# Comments on any further information/submissions received by Deadline 1

Borough Council of  
King's Lynn &  
West Norfolk

Planning Inspectorate reference: EN010110

## Proposed Medworth Energy from Waste Combined Heat and Power Facility

Figure 8.1 Air quality survey monitoring locations , ES Chapter 8: Air Quality

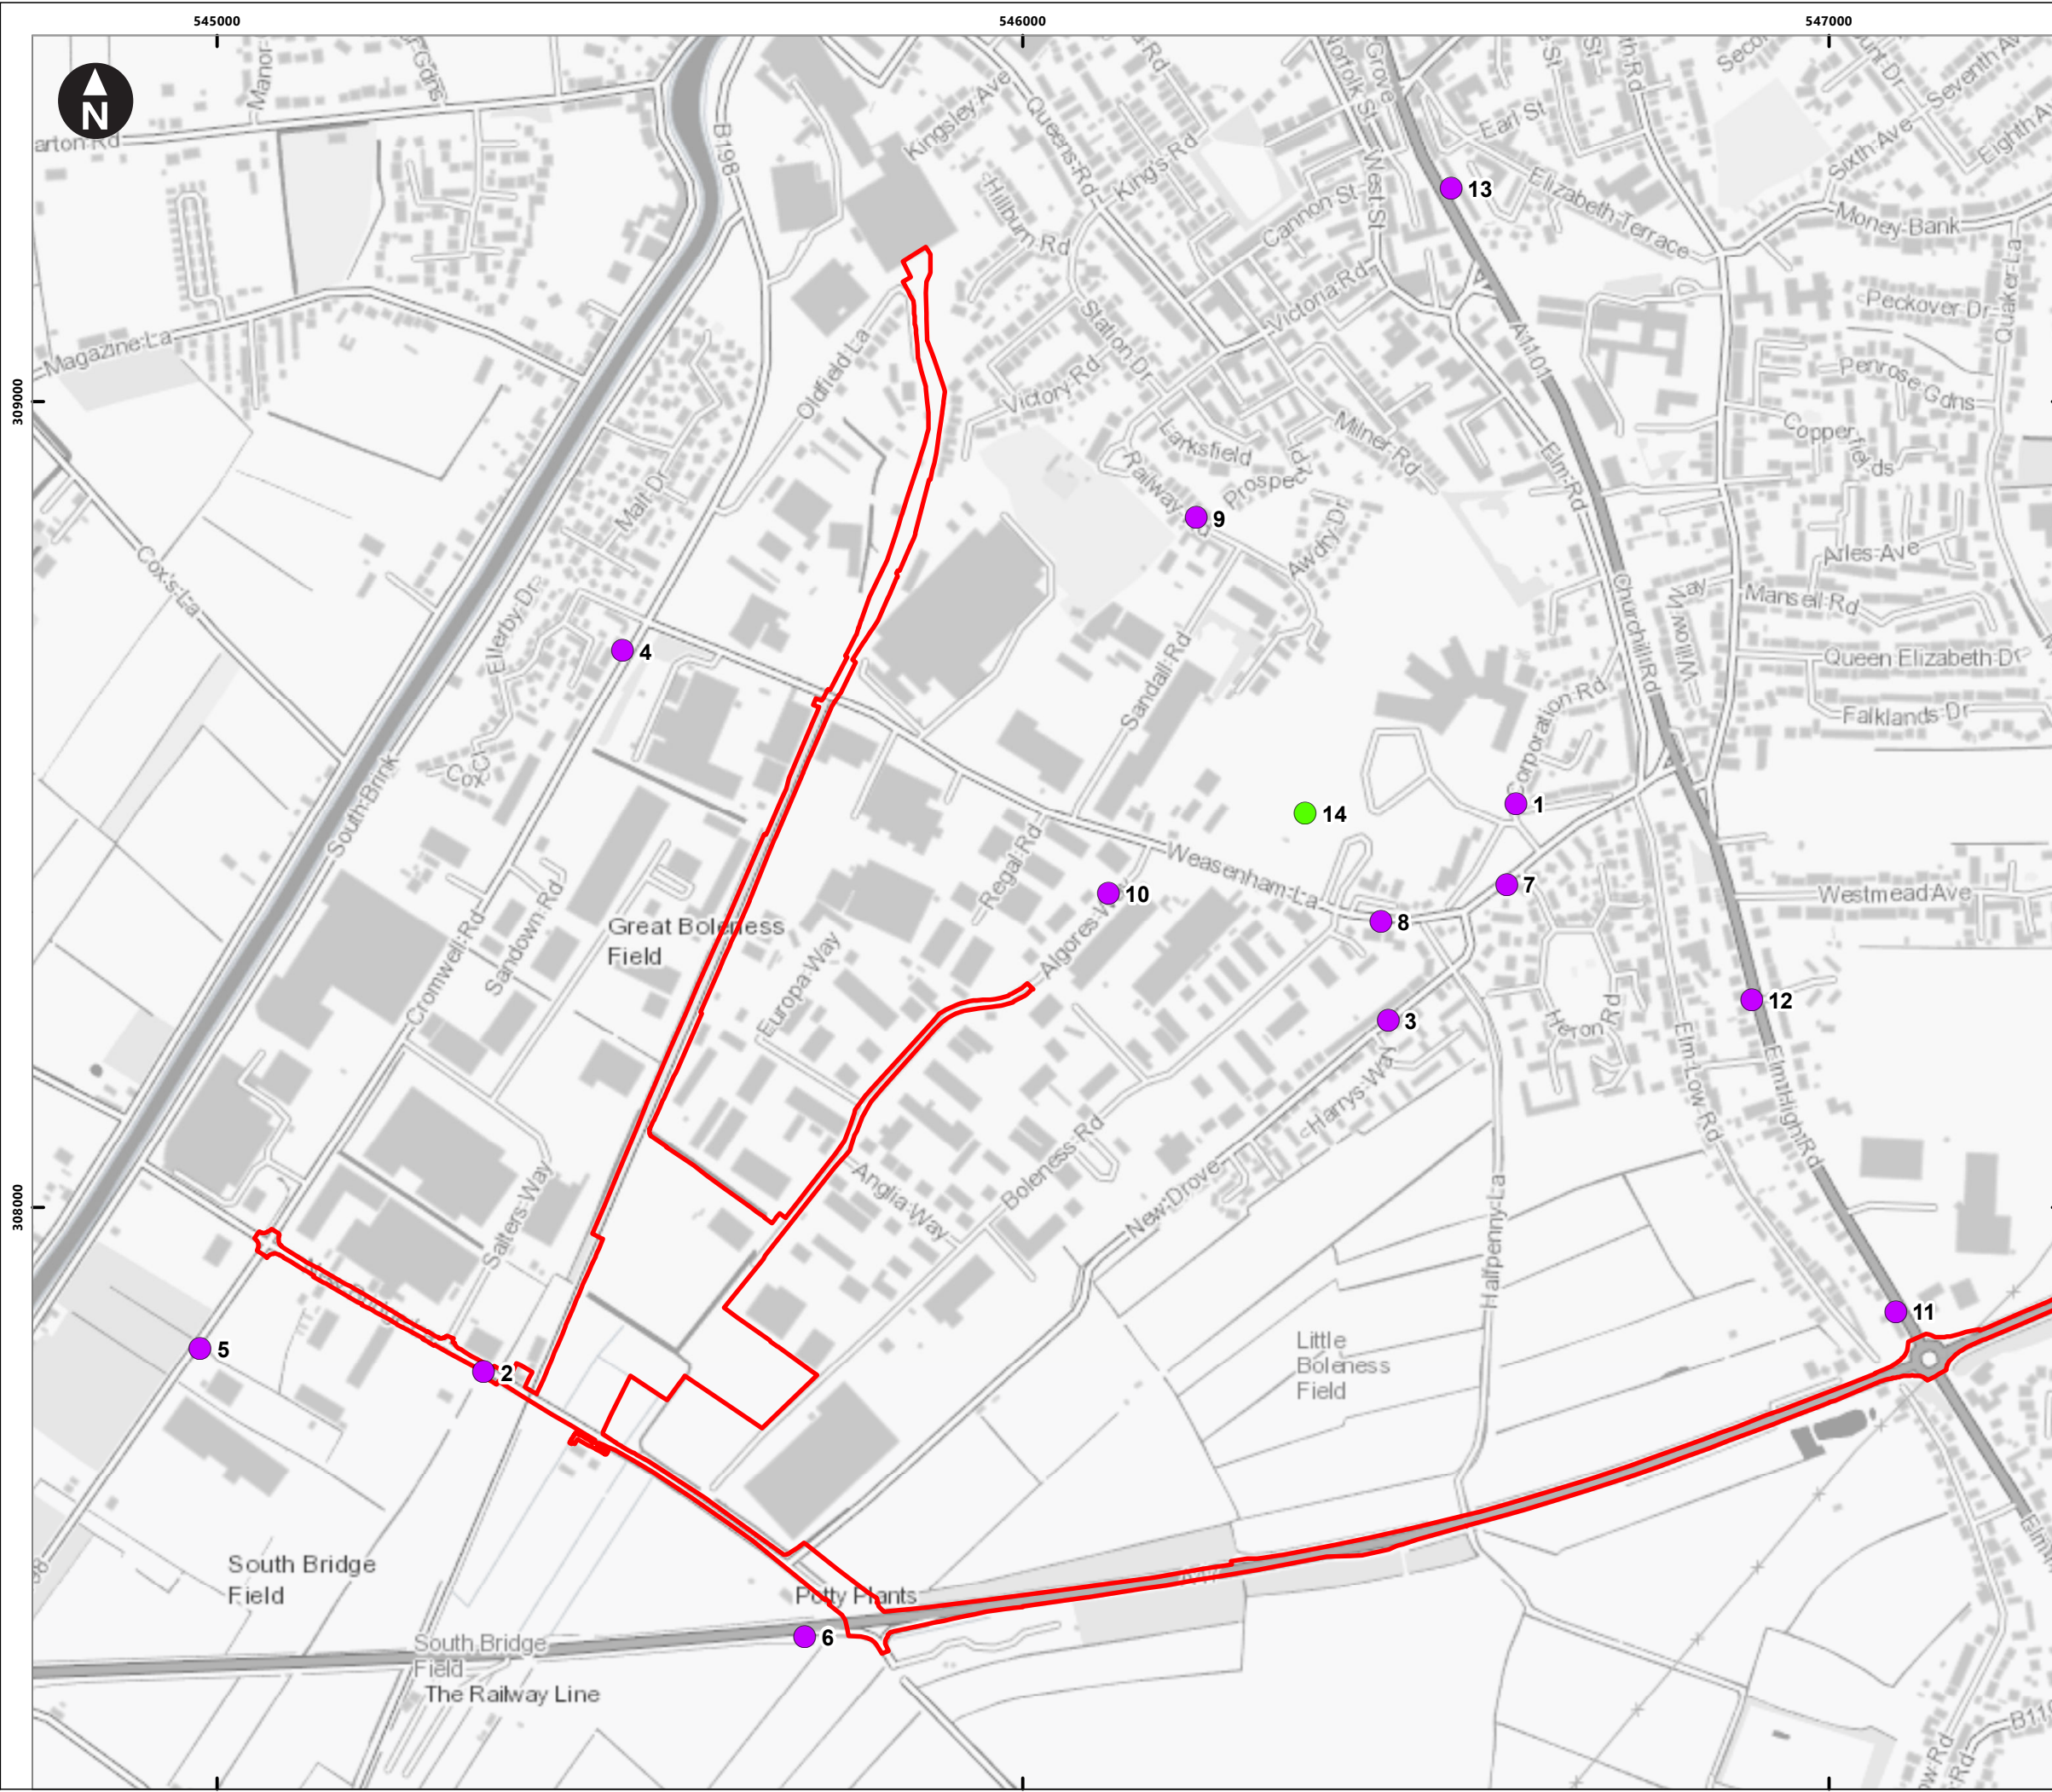
The locations as depicted within the Outline AQMS were however submitted some while ago and prior to the Air Quality Assessments carried out. Therefore we would advise that the locations and type of monitoring should be updated in line with comments within the LIR i.e. that considers particulate matter emissions within an urban background type area within BCKLWN. This may require a financial contribution towards the existing roadside monitoring and as agreed new monitoring locations to be provided by the applicant i.e. that require both a s.106 and/or a DCO Requirement. The AQ monitoring scheme would benefit from joint remote interrogation and downloading rather than separately delivered by each local authority to help reassure public about AQ. It may also be of benefit to consult with the relevant public health sections of both NCC and CCC on this AQMS strategy.
